KIRKLEES METROPOLITAN COUNCIL INVESTMENT & REGENERATION SERVICE

DELEGATED DECISION TO DETERMINE APPLICATIONS FOR CONSENT, AGREEMENT OR APPROVAL REQUIRED BY CONDITION

Reference No:	2026/44/91136/E
Site Address:	rear of, 28, Northorpe Lane, Northorpe, Mirfield, WF14 0QN
Description:	Discharge of details reserved by conditions 3 (retaining walls (materials), 4 (retaining walls (specification), 5 (temporary and permanent retaining structures), 12 (waste arrangements (permanent), 13 (waste arrangement (temporary), 29 (charging electric vehicles) on previous permission 2021/91914 for demolition of one dwelling and erection of 44 dwellings with access and associated infrastructure
Recommending Officer:	Ellie Thornhill

DECISION – Discharge of Condition – Split Decision

REINFORCED CONCRETE RETAINING WALL DETAILS

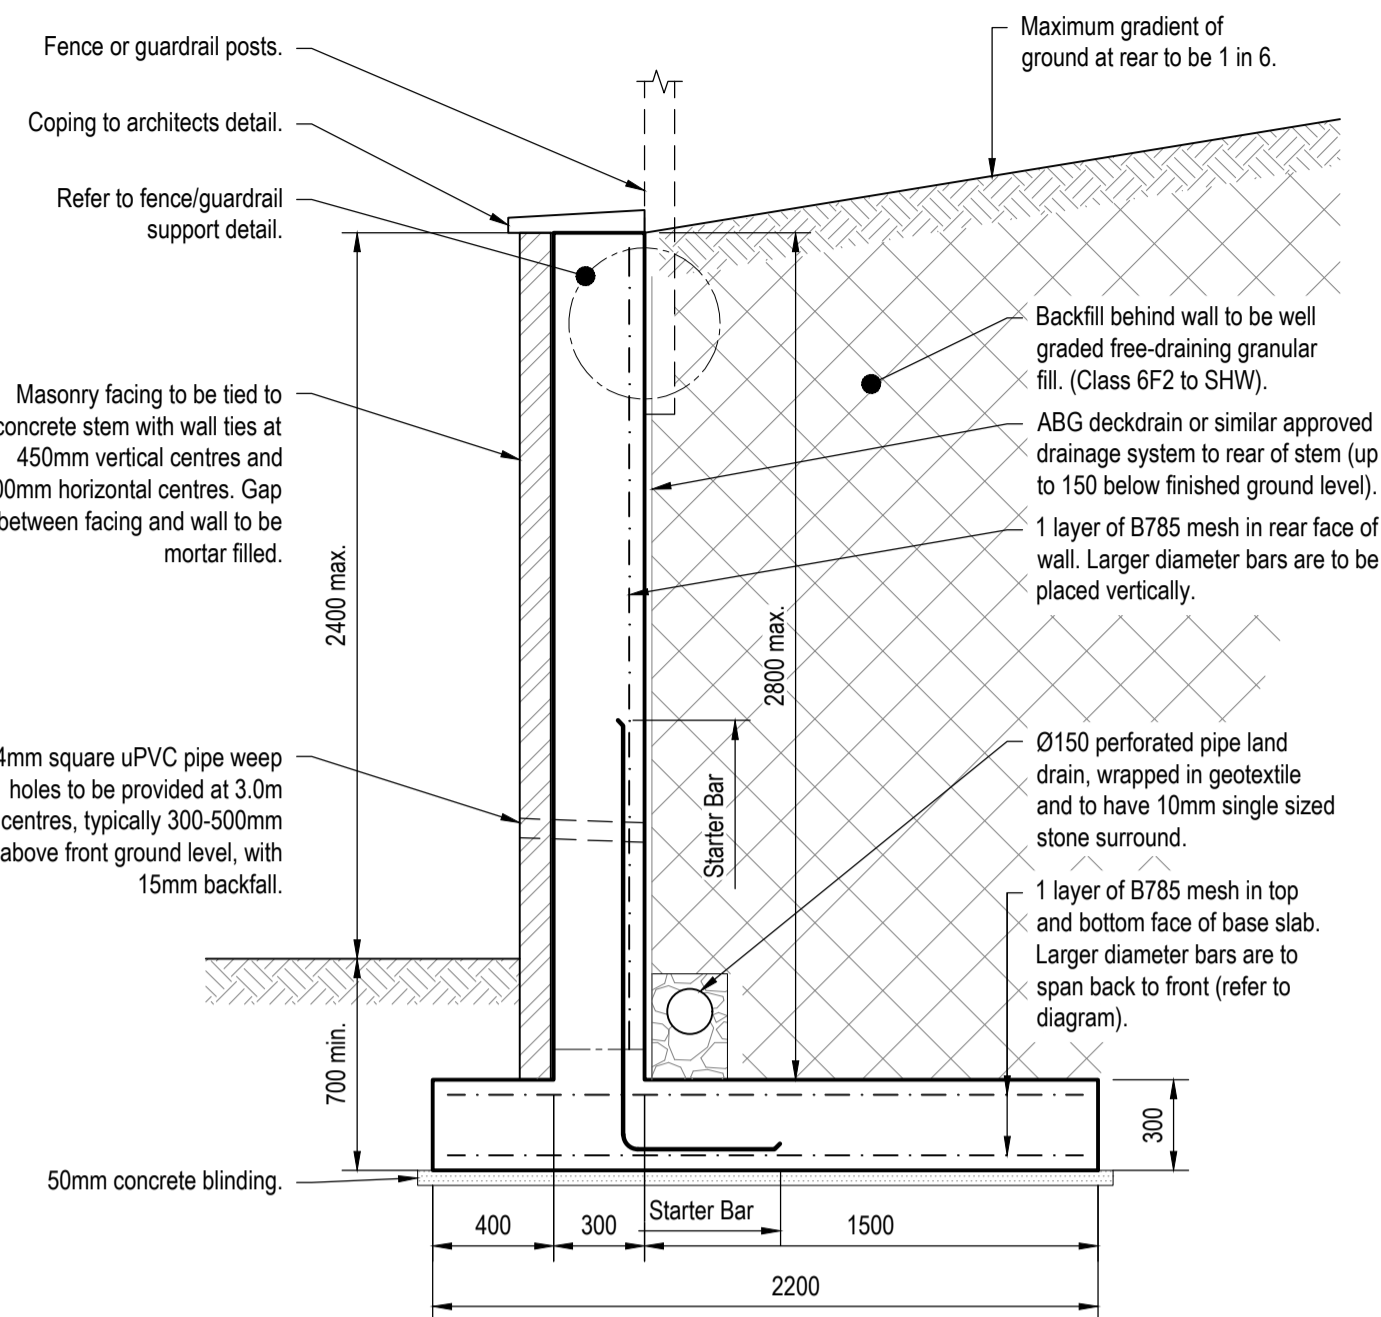
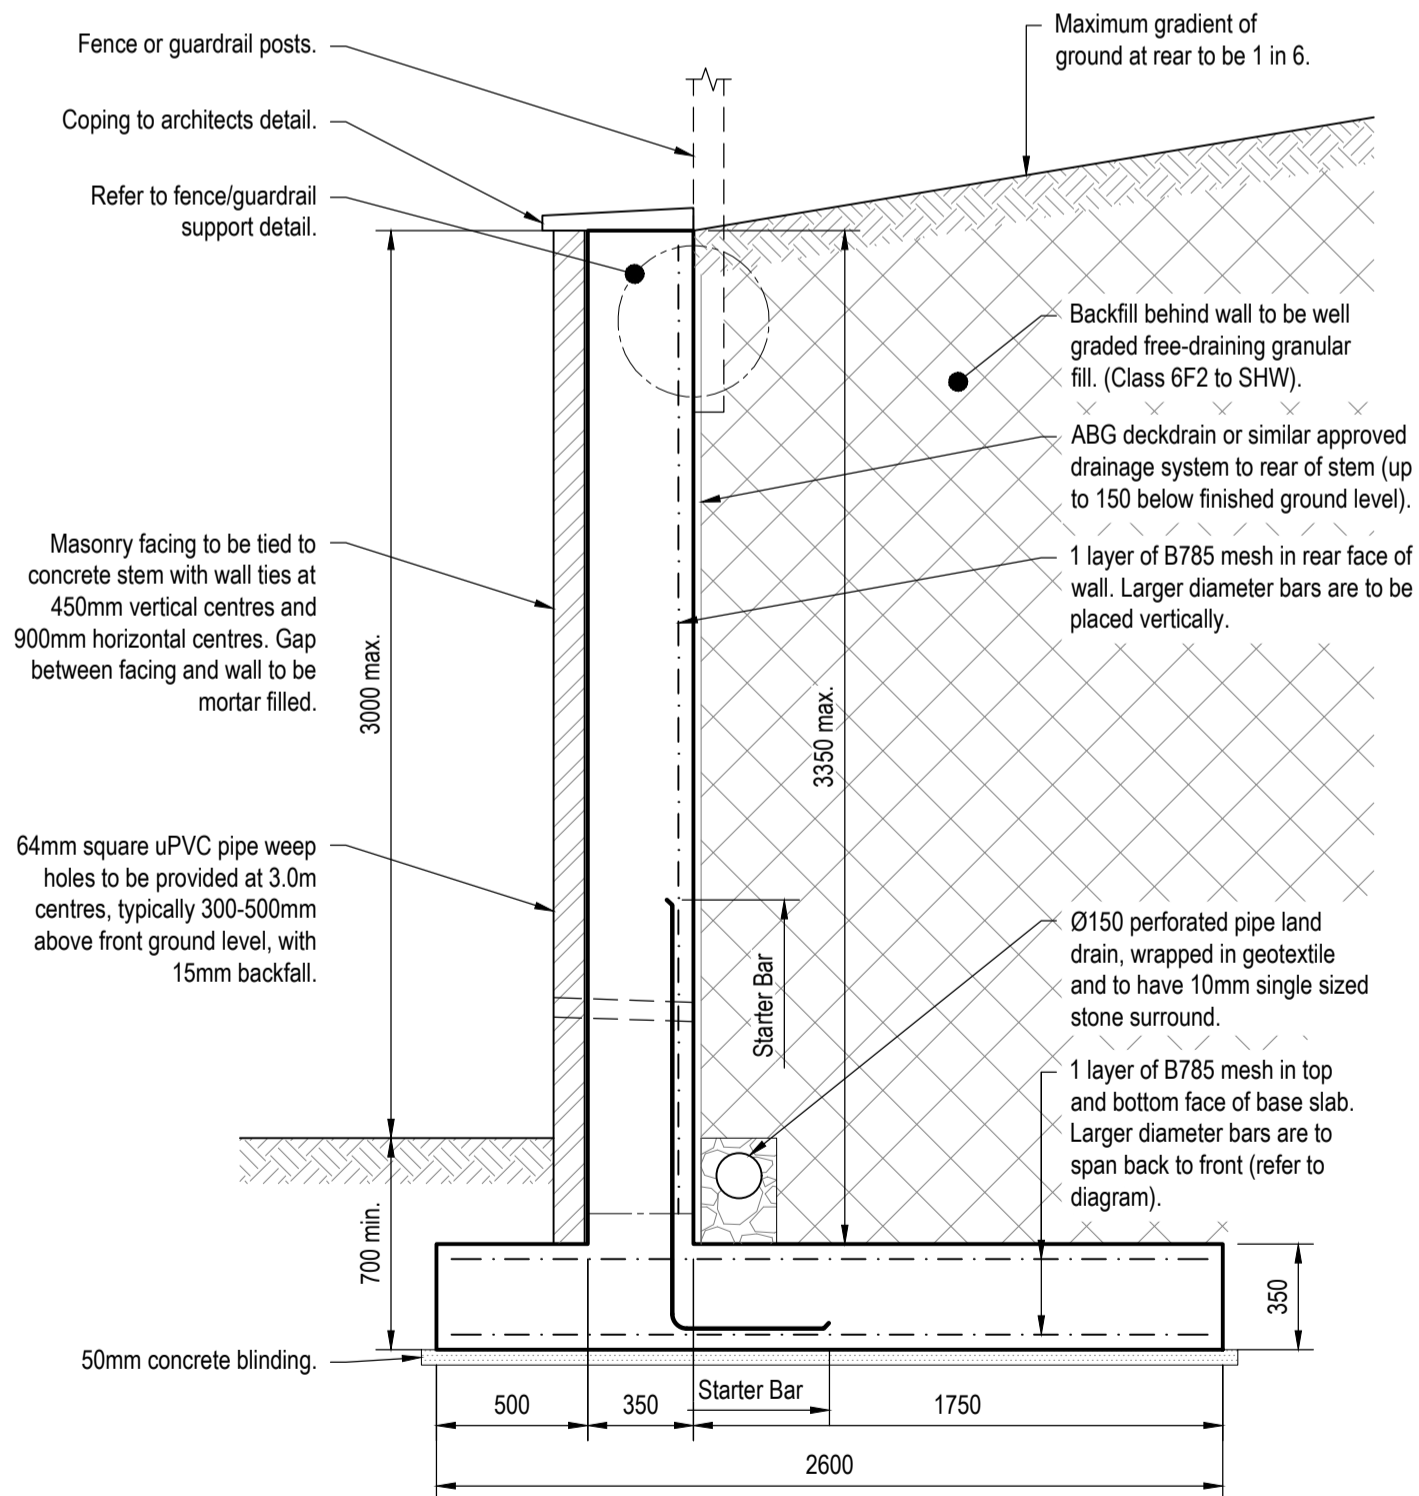
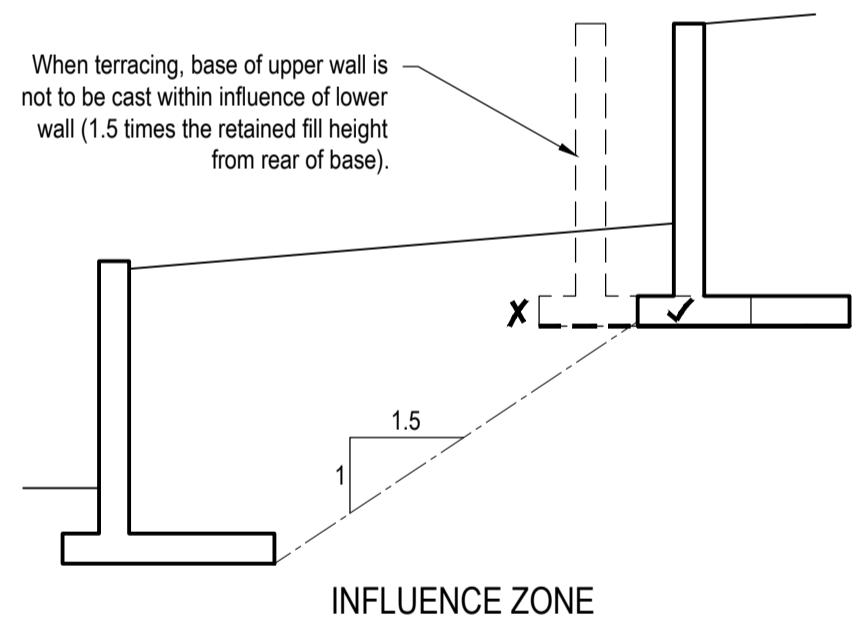
This condition cannot be discharged, as the required information including the provision of dimensioned X-sectional details (based on max retained height) for the proposed retaining walls adjacent to the new highway have not been provided so as to establish whether their design will be subject to a formal technical approval process.

the provision of dimensioned X-sectional details (based on max retained height) for the proposed retaining walls adjacent to the new highway have not been provided so as to establish whether their design will be subject to a formal technical approval process.
